CITY OF ALBUQUERQUE

Re: Carlisle and Menaul
Traffic Impact Study (H16D083F)
Submittal dated March 4, 2025
Via email cvermillion@bhinc.com and ABQ-PLAN

The Traffic Impact Study (Study) received on April 2, 2025, has been reviewed by the City of Albuquerque Planning Development Transportation Section and has the following comments.

**SITE PLAN AND CROSS SECTION
EXHIBIT**

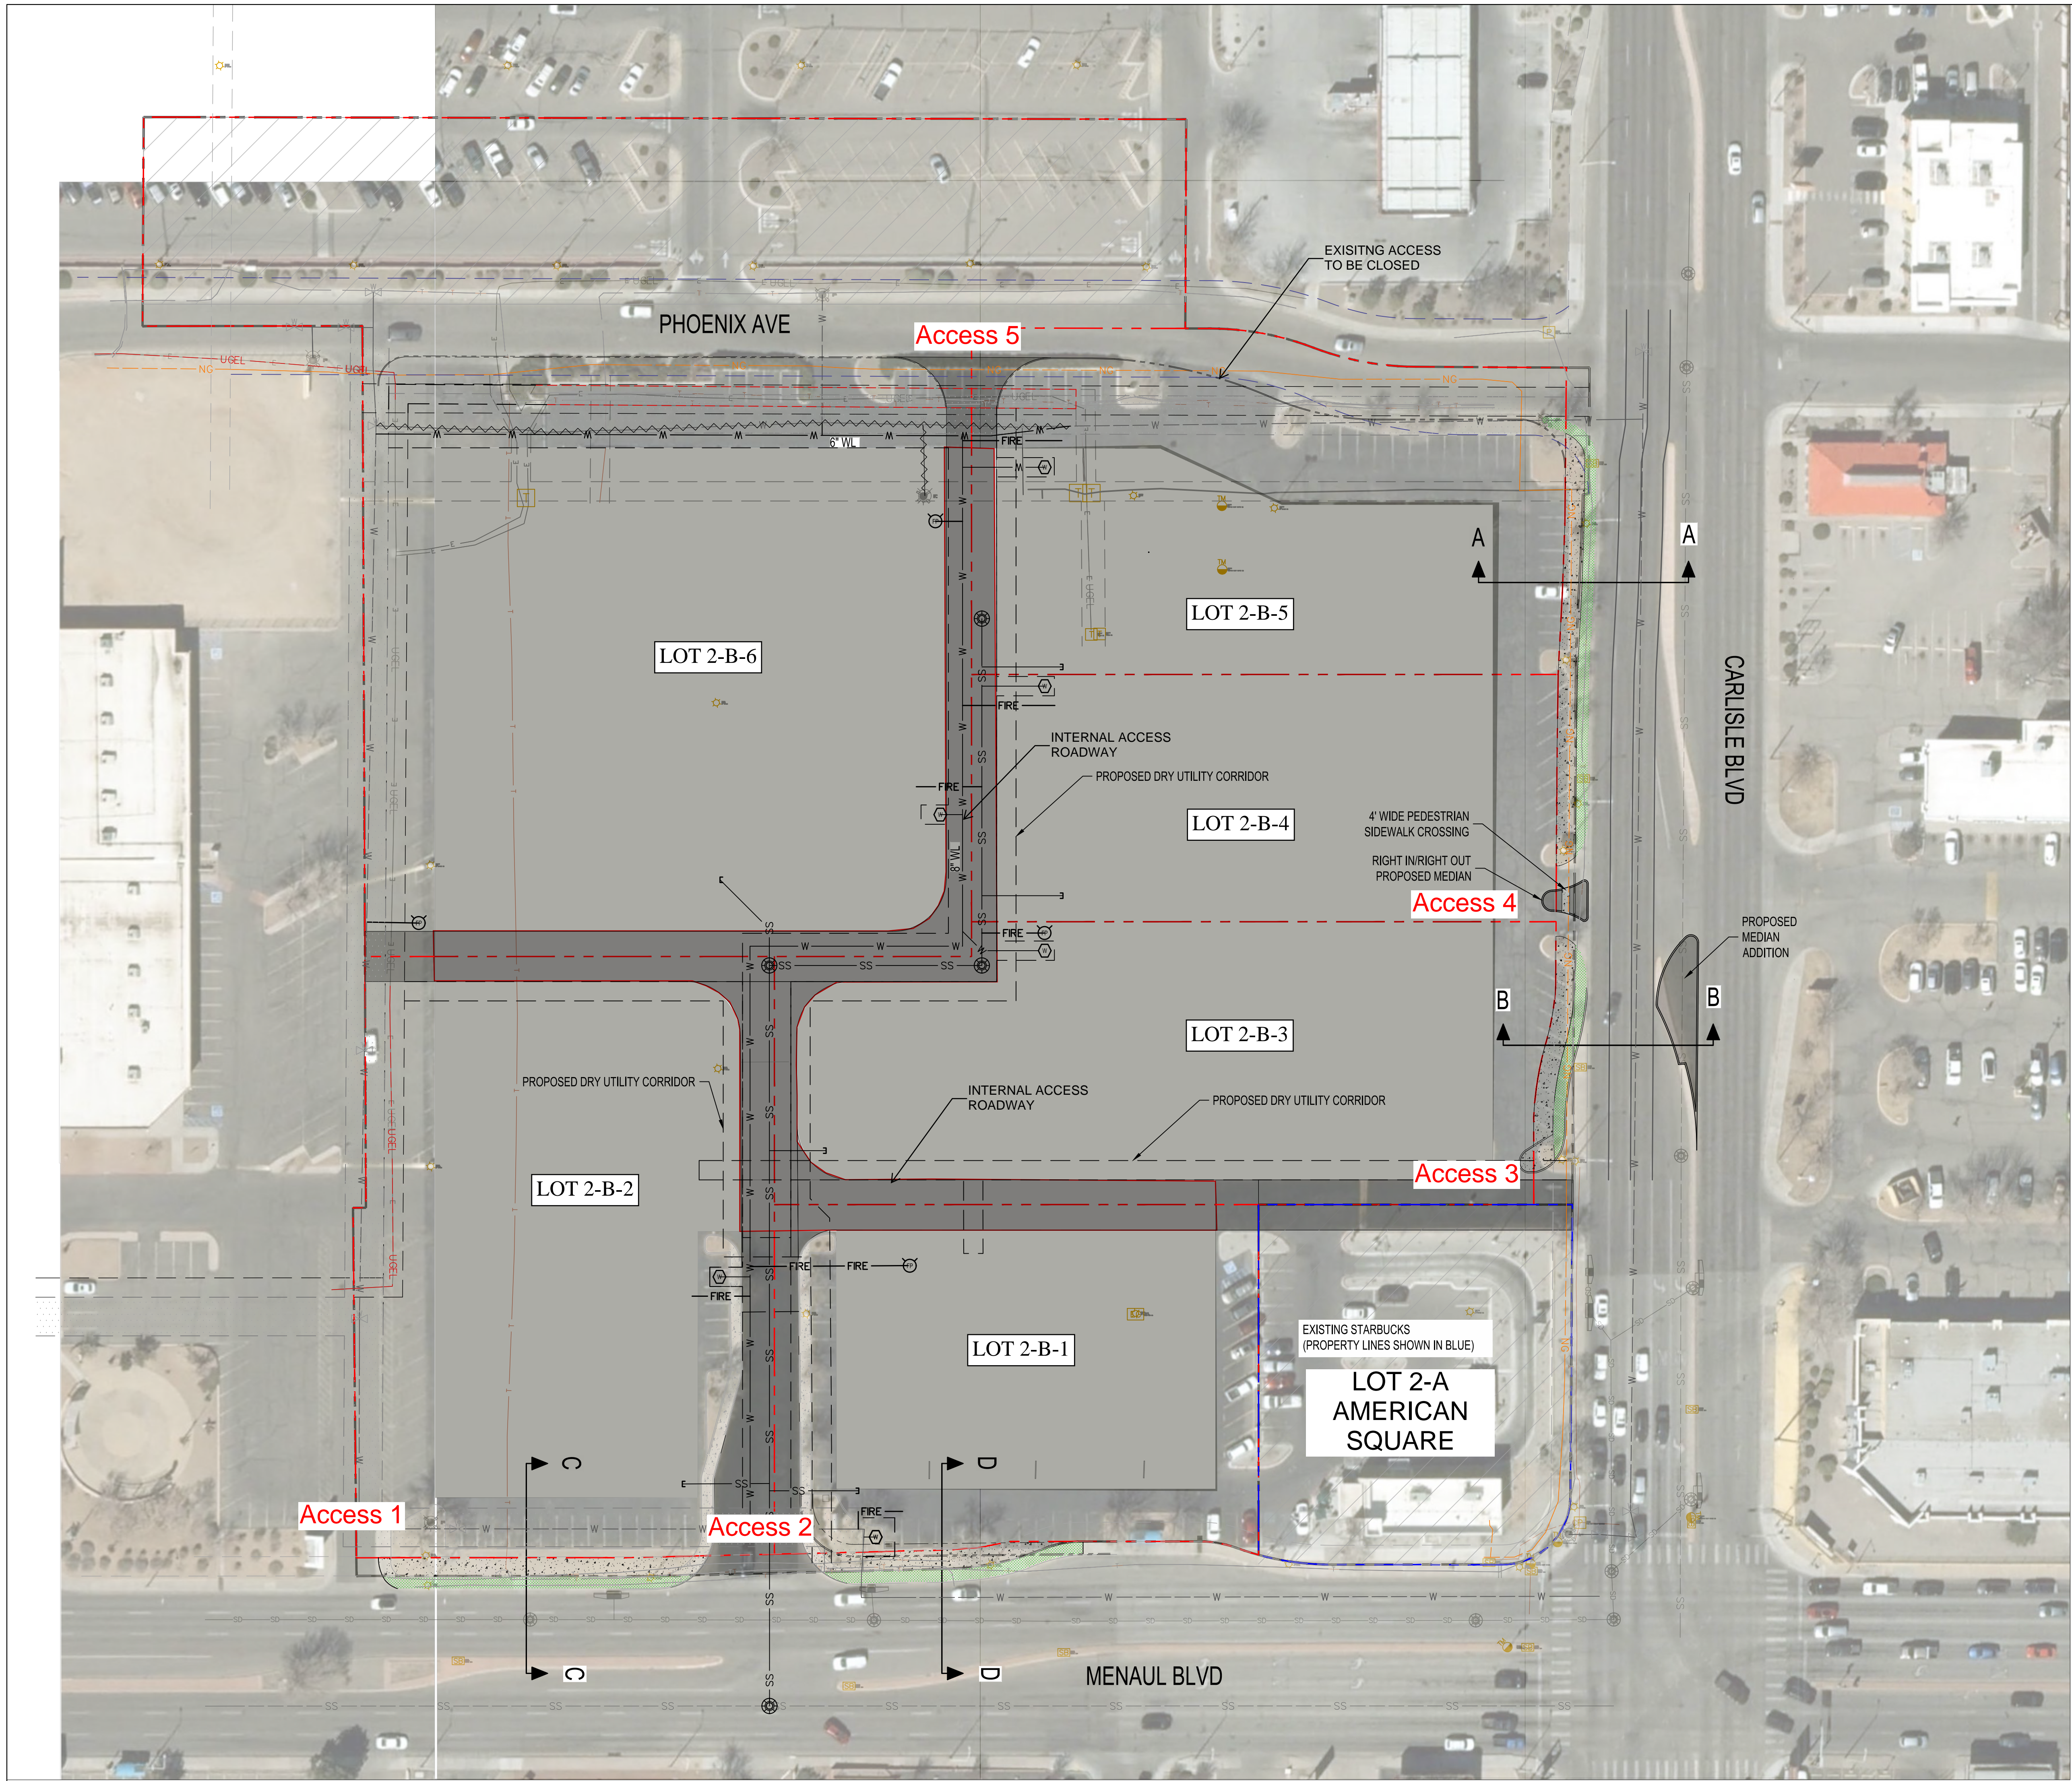
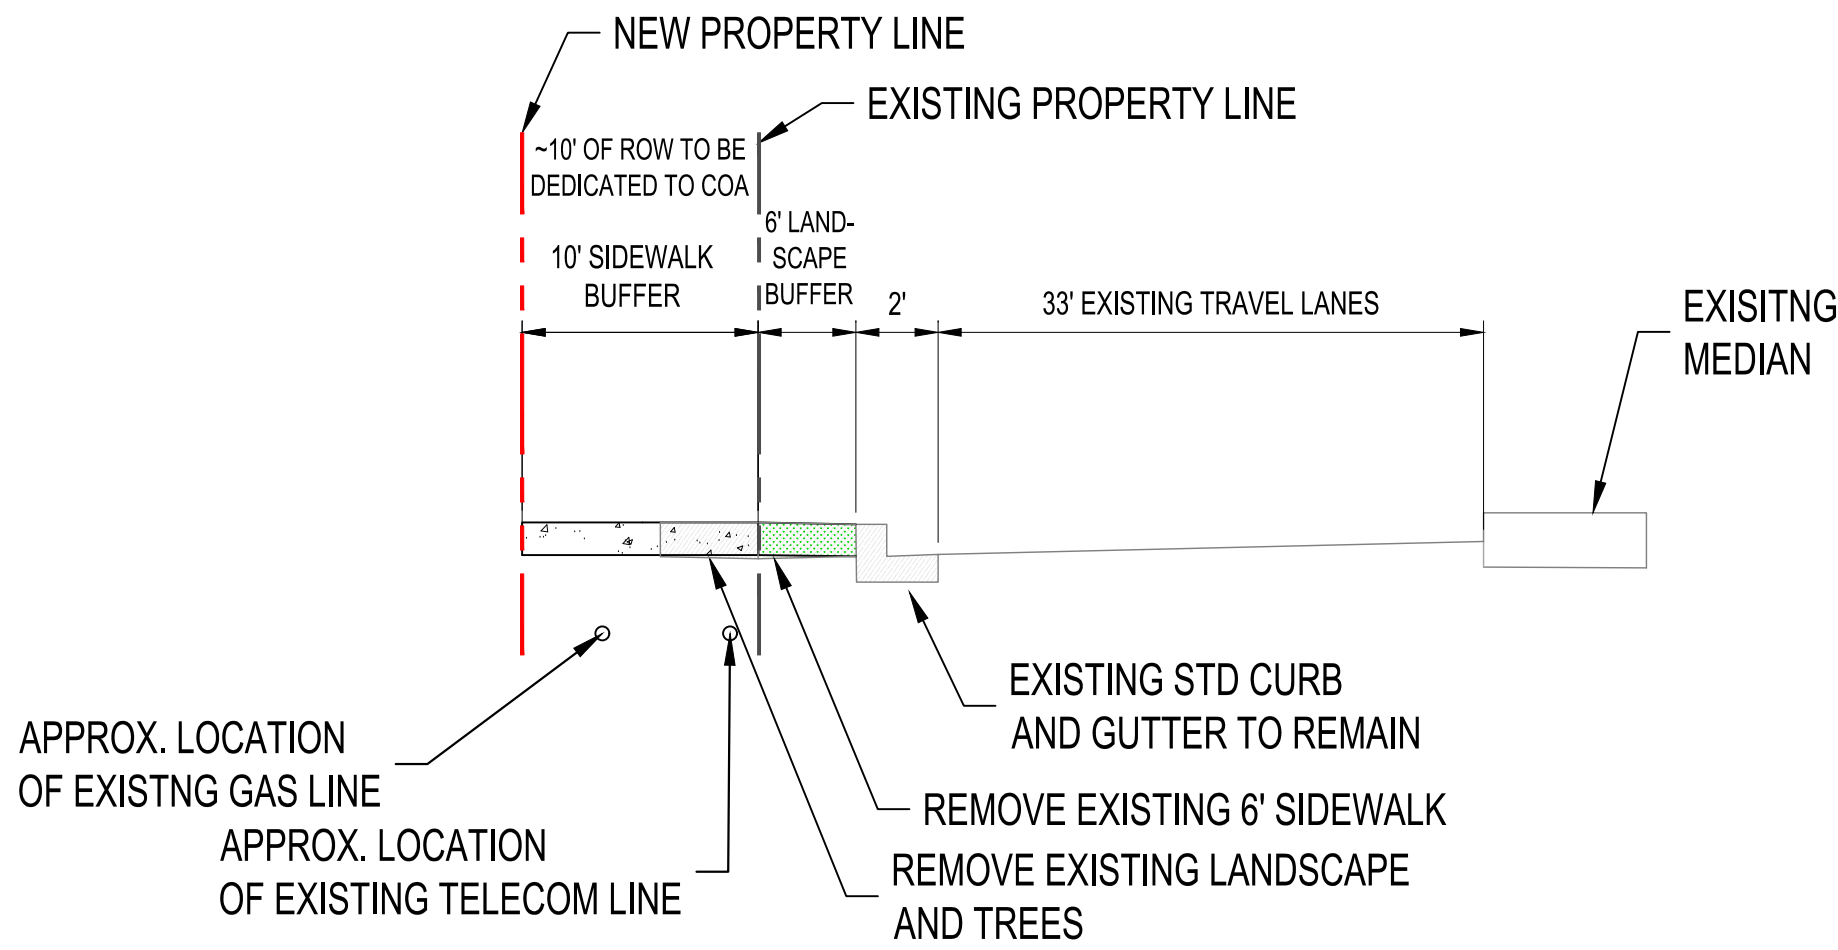
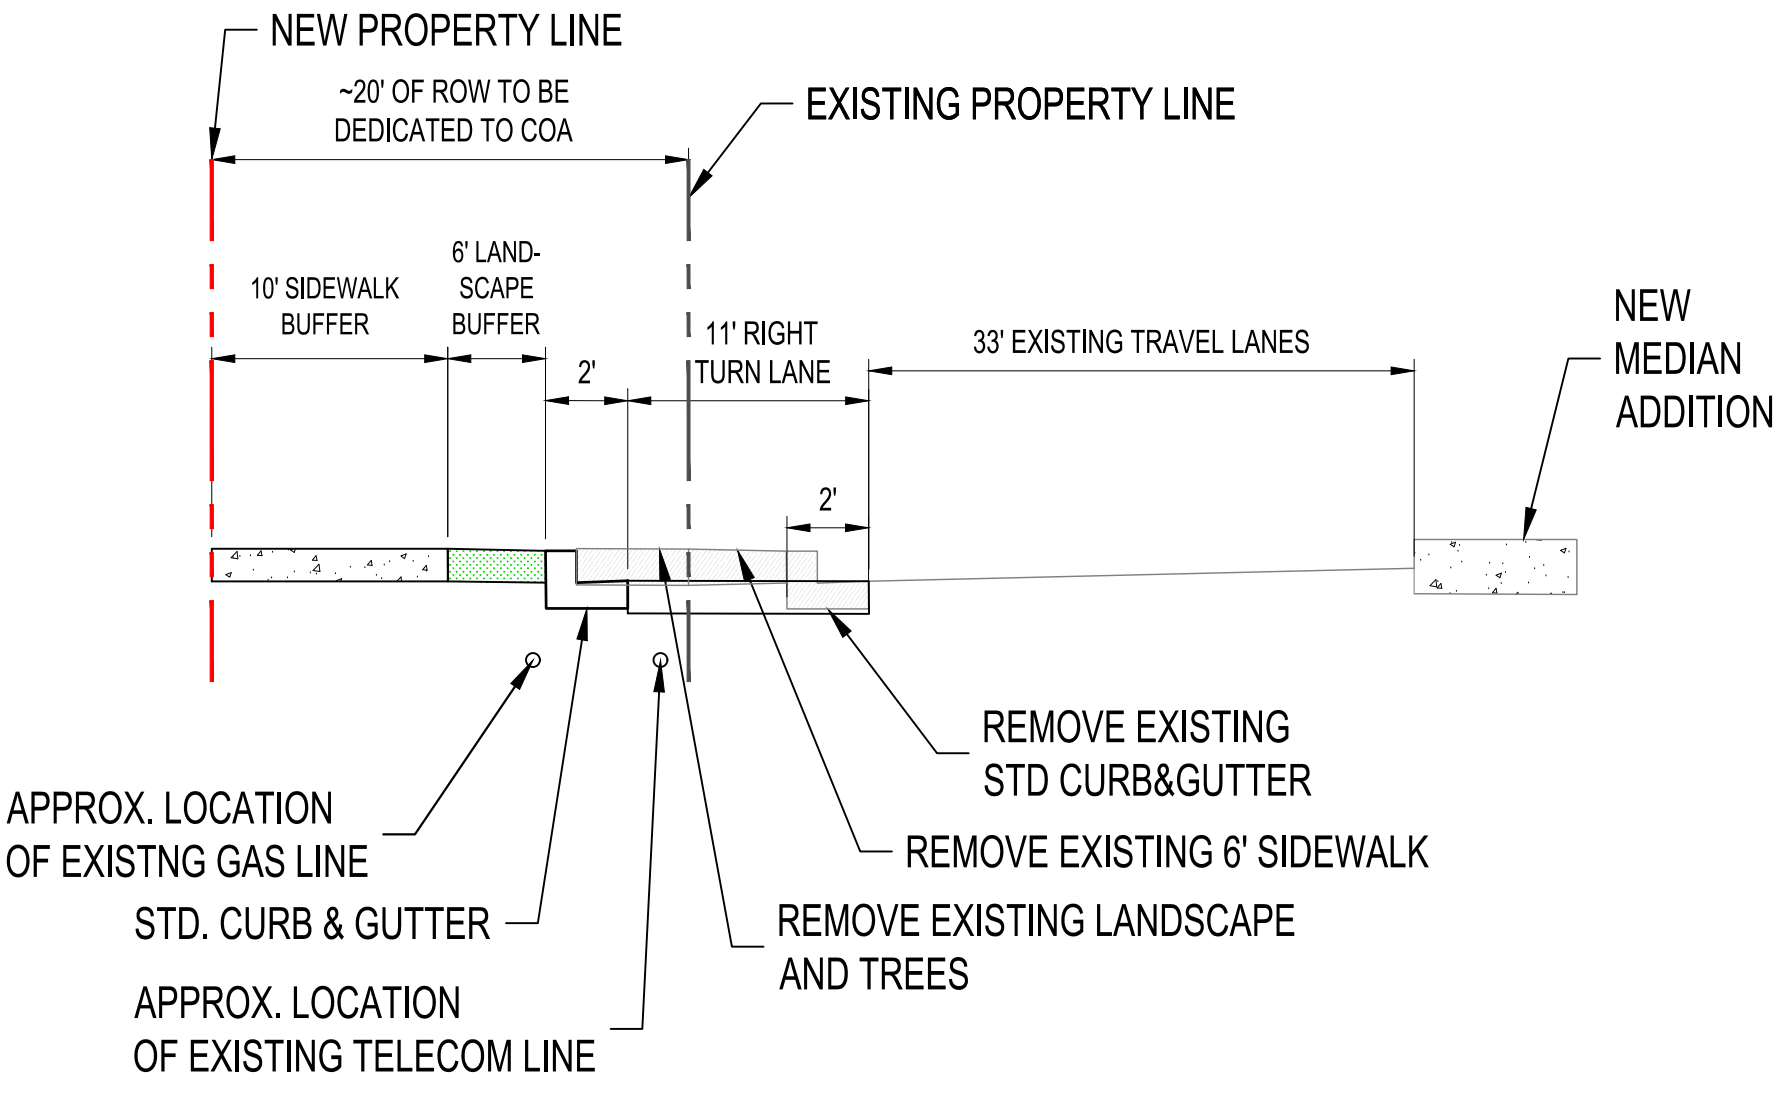
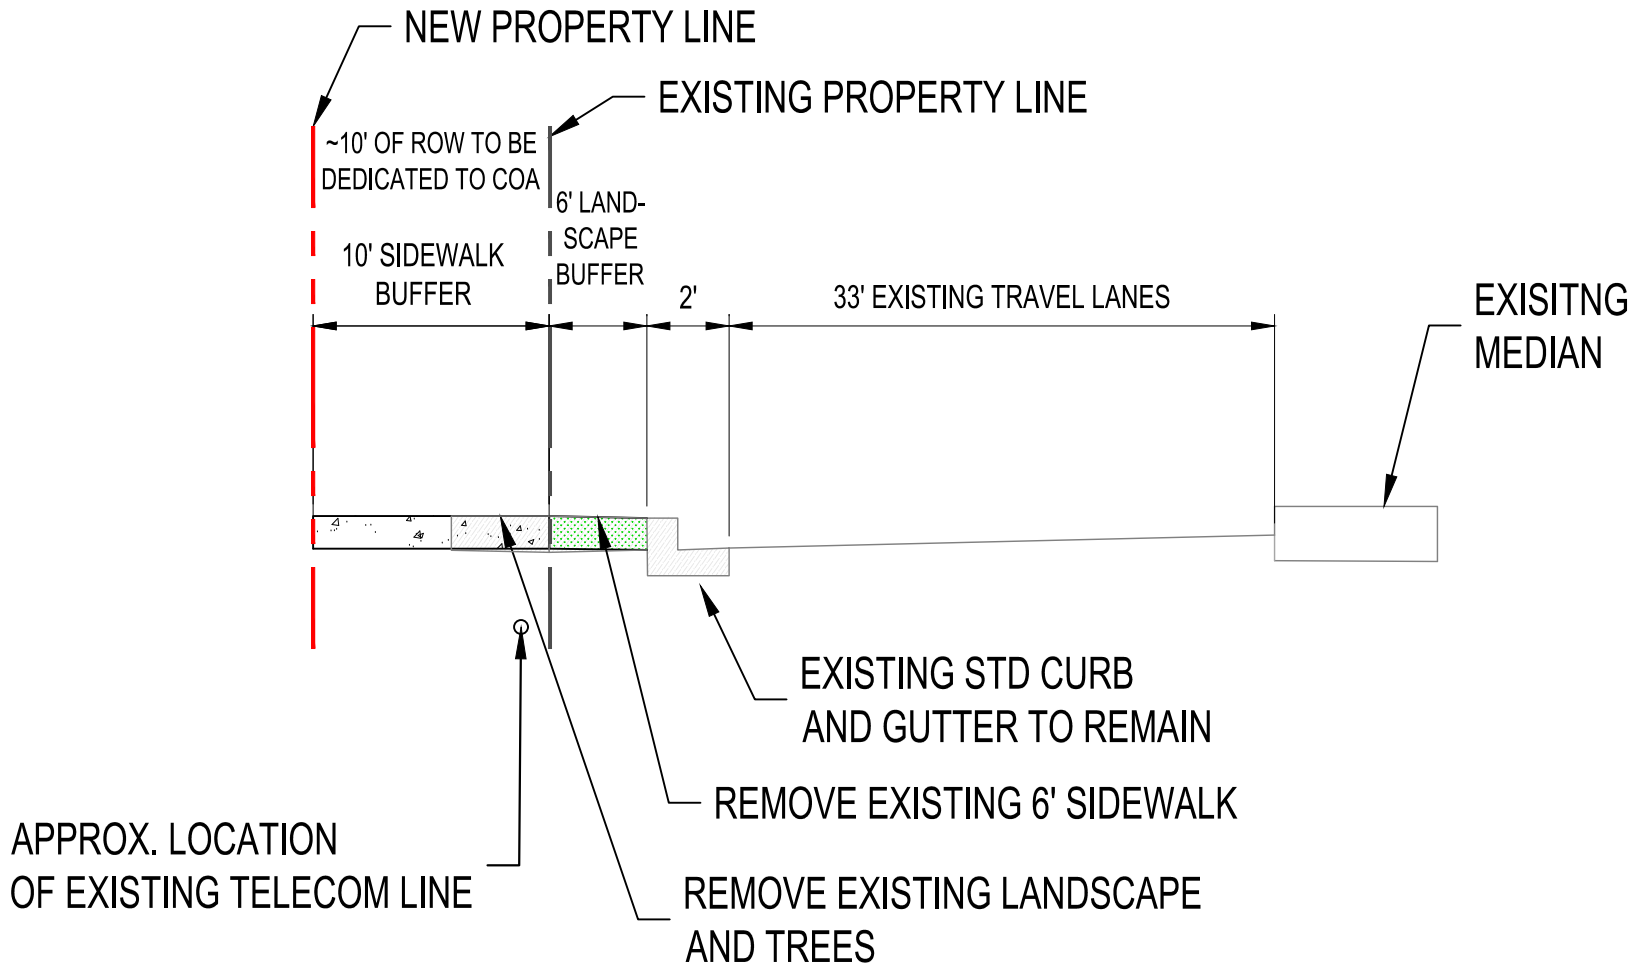
1. I would like to see a sketch of the proposed median change on Carlisle for Access #4. I want to make sure of what this will look like. In addition to the median changes, please show a “pork chop” at the entrance to indicate to drivers that it will only be right -in, right out.
